**LAND ADJACENT TO 3 MORLEY COTTAGES
BORRINGDON HILL, PLYMOUTH, PL7 4DH**

**PROPOSED NEW DETACHED DWELLING
RESERVED MATTERS APPLICATION
DESIGN STATEMENT**

Reserved Matters application following Outline Planning Consent reference: 19/00845/OUT, dated 25th July 2021 and subsequent pre-application Development Enquiry reference: 19/02022/MOR. A subsequent meeting with the Case Officer was convened on 8th January 2020 and the comments received are noted later.

TITLE	AUTHOR
PROPOSED NEW BUILD	JH
No.3 MORLEY COTTAGES	
BORRINGTON HILL, PLYMOUTH, PL7 4DH	
CLIENT	16/01/2020
MARK HINCHLIFFE	SCALE
	1:100 @ A3
DETAIL	CHECKED
PROPOSED TOP FLOOR PLAN AND ROOF PLAN

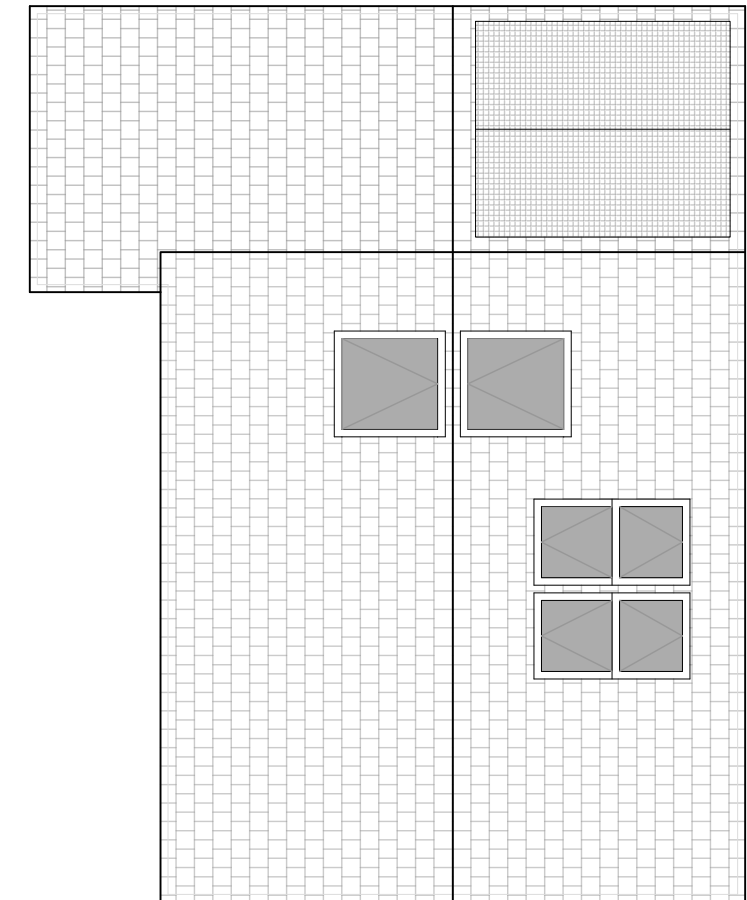
- Roof materials should relate to the cottages (for street scene purposes)
 - Ensure roof is designed to adequately accommodate PVs
- Further plans should better articulate principal access to the dwelling and how this is reached via parking spaces

TITLE	PROPOSED NEW BUILD No.3 MORLEY COTTAGES BORRINGTON HILL, PLYMOUTH, PL7 4DH	AUTHOR	JH
CLIENT	MARK HINCHLIFFE	DATE	16/01/2020
DETAIL	SITE PLAN	SCALE	1:100 @ A3
		CHECKED

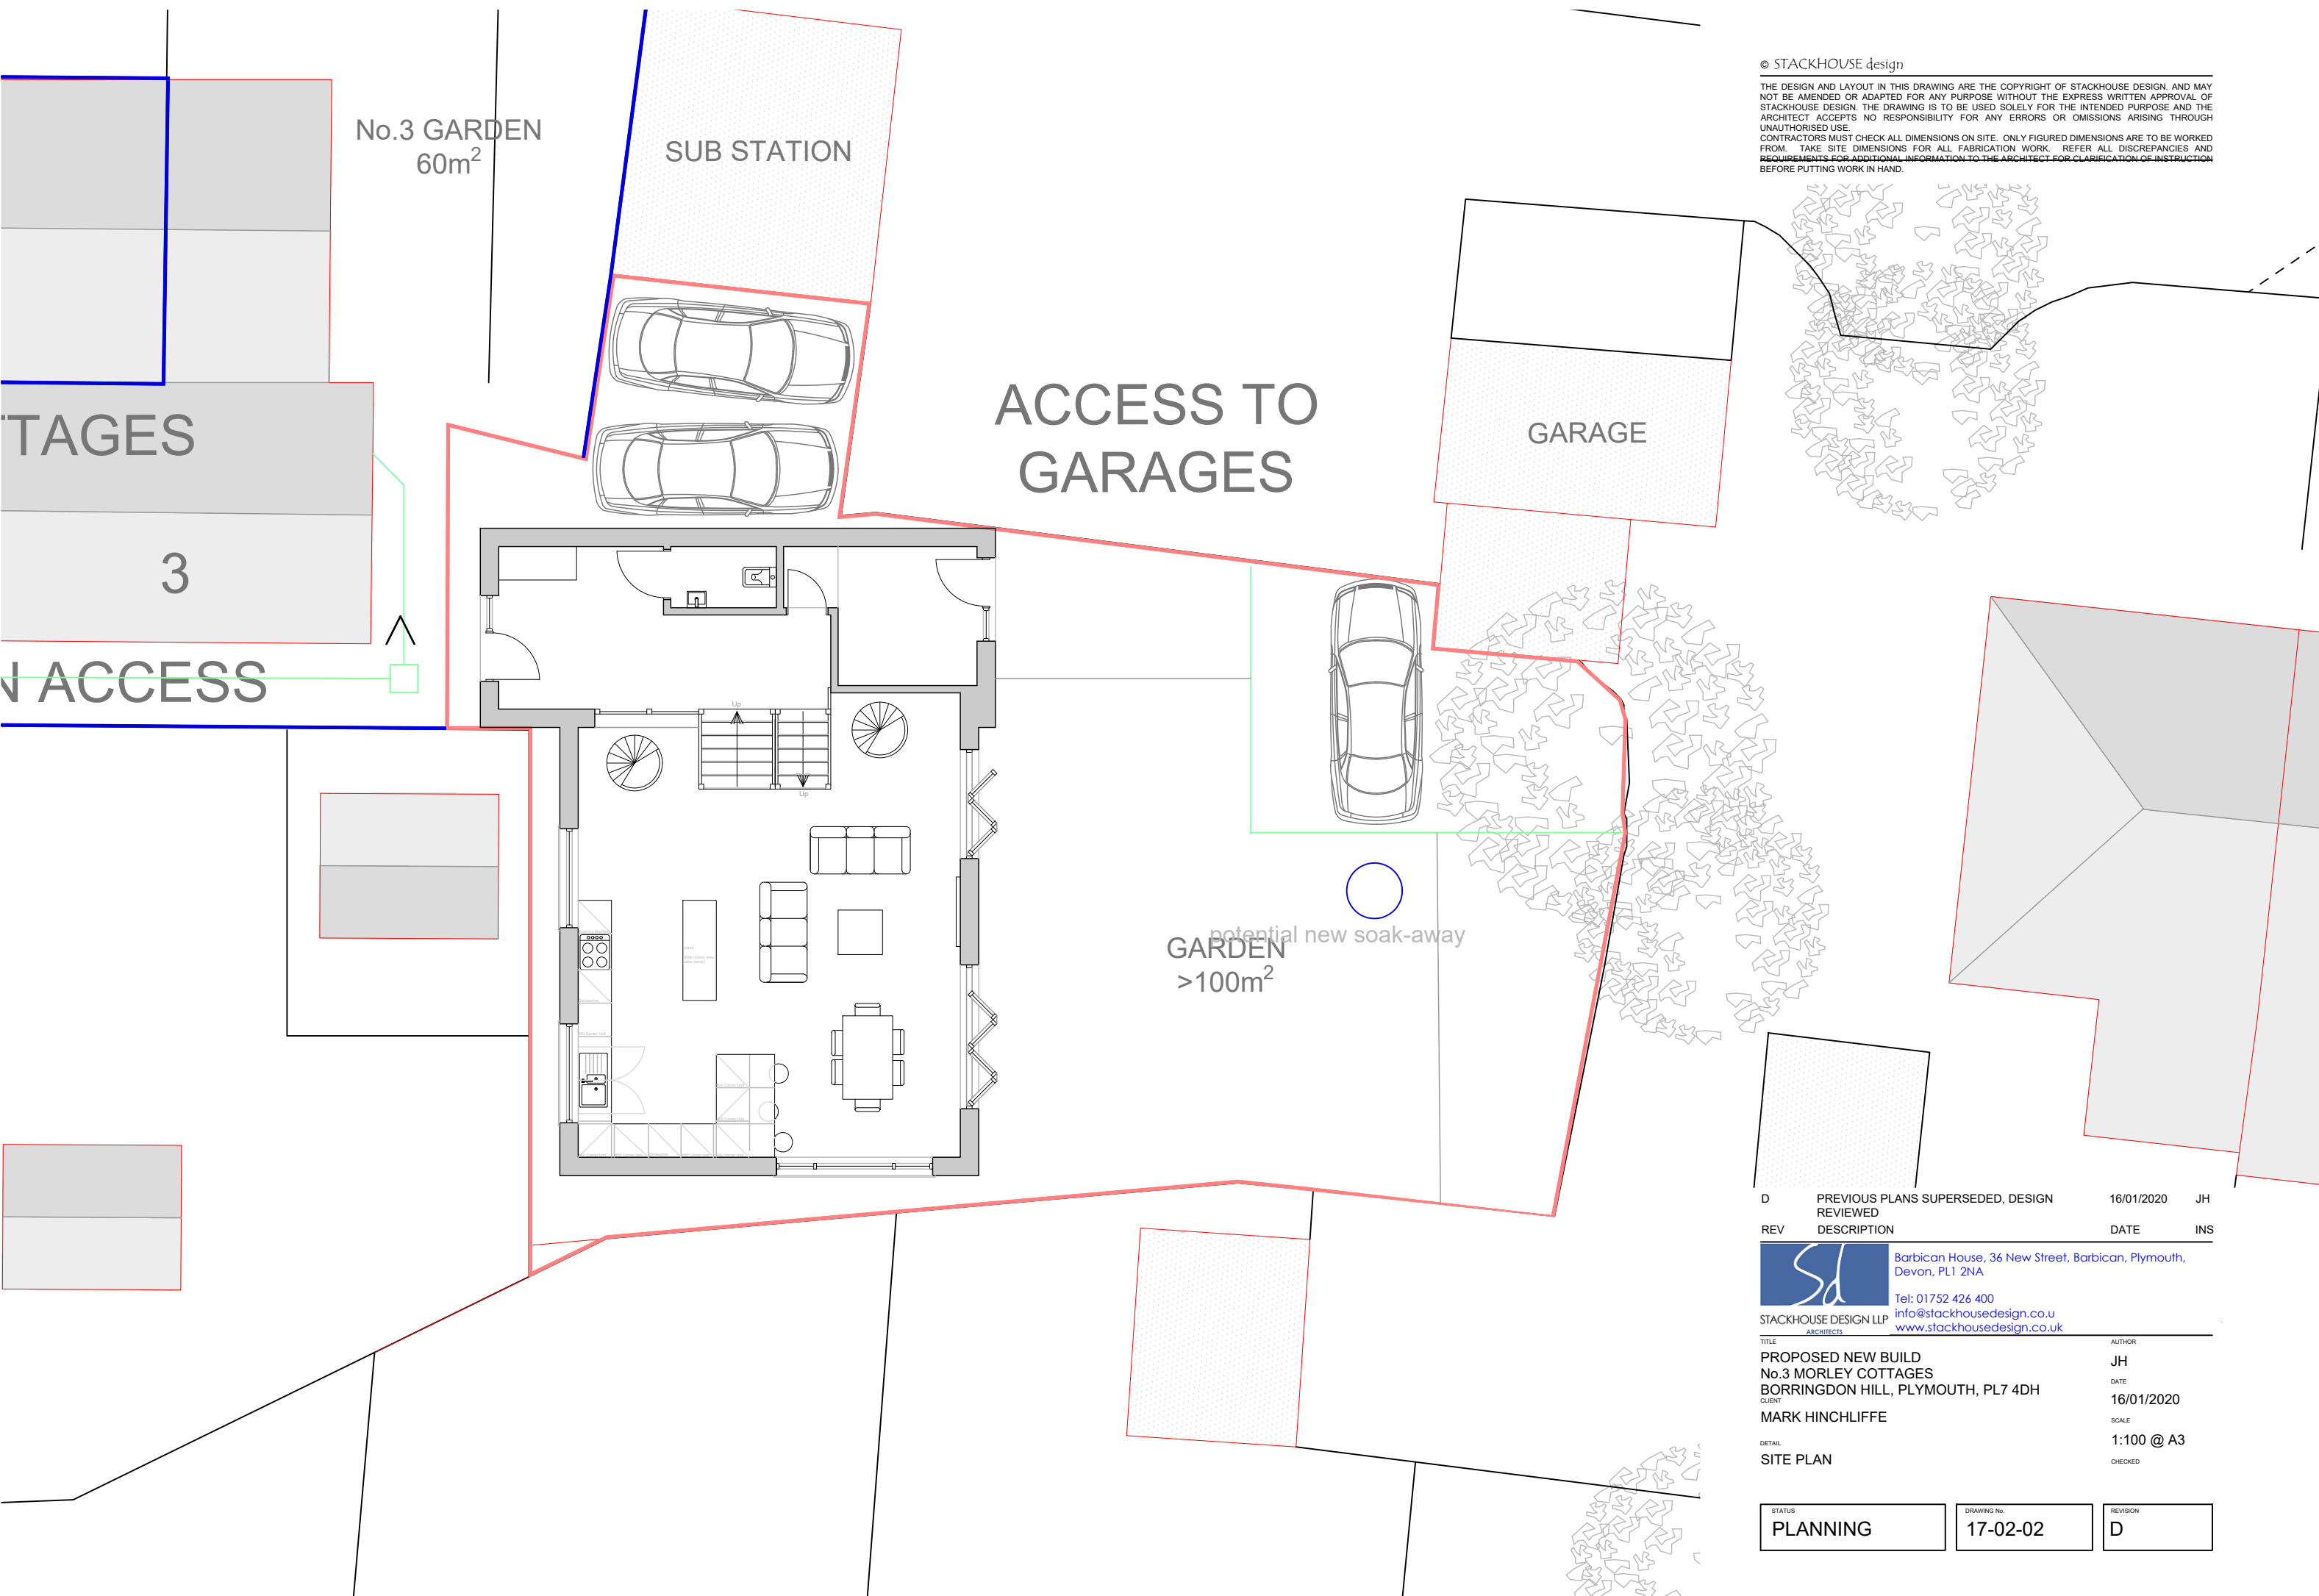
- Utilise soft and hard boundary treatments where appropriate to create enduring and attractive boundaries
- Car park surfacing needs to consider drainage to prevent surface water runoff onto private/3rd party land

- As can be seen from the 3D visual below, access to and from the car parking area is effected via flights of steps to the front and rear of the property.

- The car parking area adjacent to the existing sub-station is currently block paved and it is proposed to retain and extend it to suit, as this provides a demarcation between the public and private areas. It is then proposed to pave the parking space included within the garden area in similar materials which will offer the opportunity to reduce and contain the rainwater run-off.

TITLE	PROPOSED NEW BUILD No.3 MORLEY COTTAGES BORRINGTON HILL, PLYMOUTH, PL7 4DH	AUTHOR	JH
CLIENT	MARK HINCHLIFFE	DATE	16/01/2020
DETAIL	PROPOSED ELEVATIONS NORTH & EAST	SCALE	1:100 @ A3
CHECKED

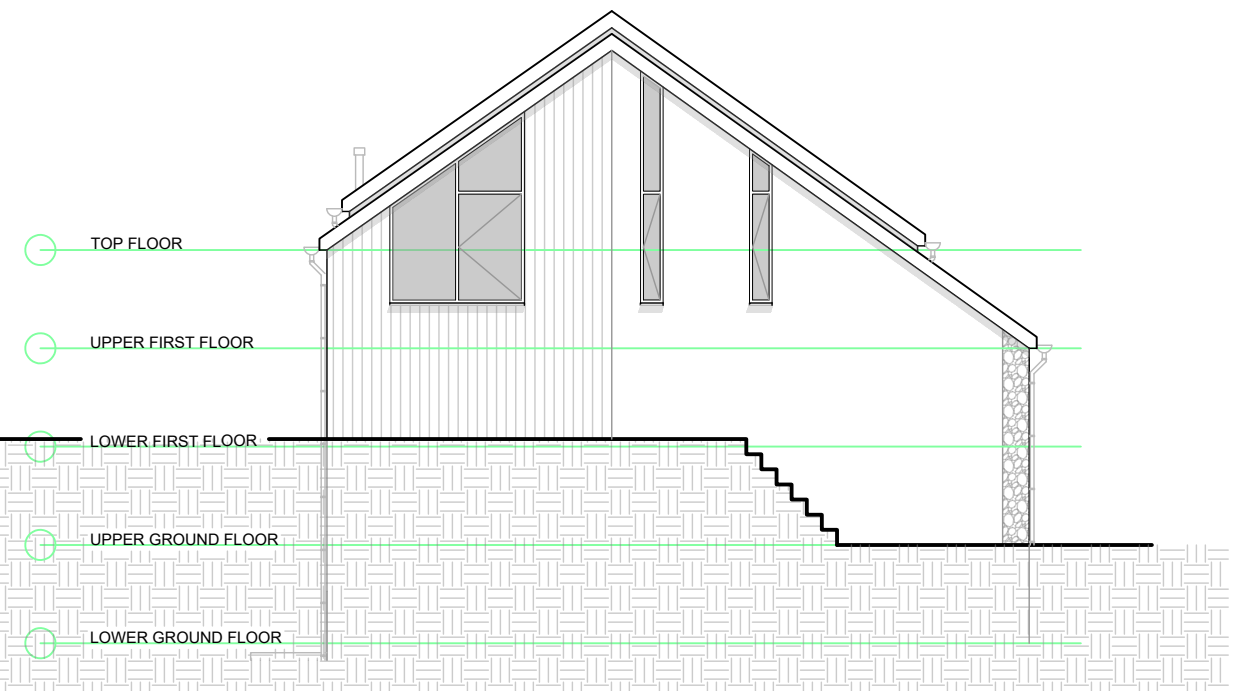
- Material palette can be expressive, although would suggest utilising render and natural stone as these best relate to Plymouth
 - High levels of glazing on the east elevation, particularly at GF level is supported

- Consider additional opening on the north and south elevations, particularly where bathrooms are located.
 - This will assist in breaking up elevations and aid ventilation

- The scale and mass of the presented drawings were retained as the design in this respect was supported by the Planning Officer.
- With regards to the materials palette, render and natural stone have been incorporated on the frontage facing Borringdon Hill together with

Cedral cladding to the rear where a more contemporary appearance is to be created.

- Additional openings were provided in certain areas which help not only to break up the facades but also improve the quality of the interior spaces.
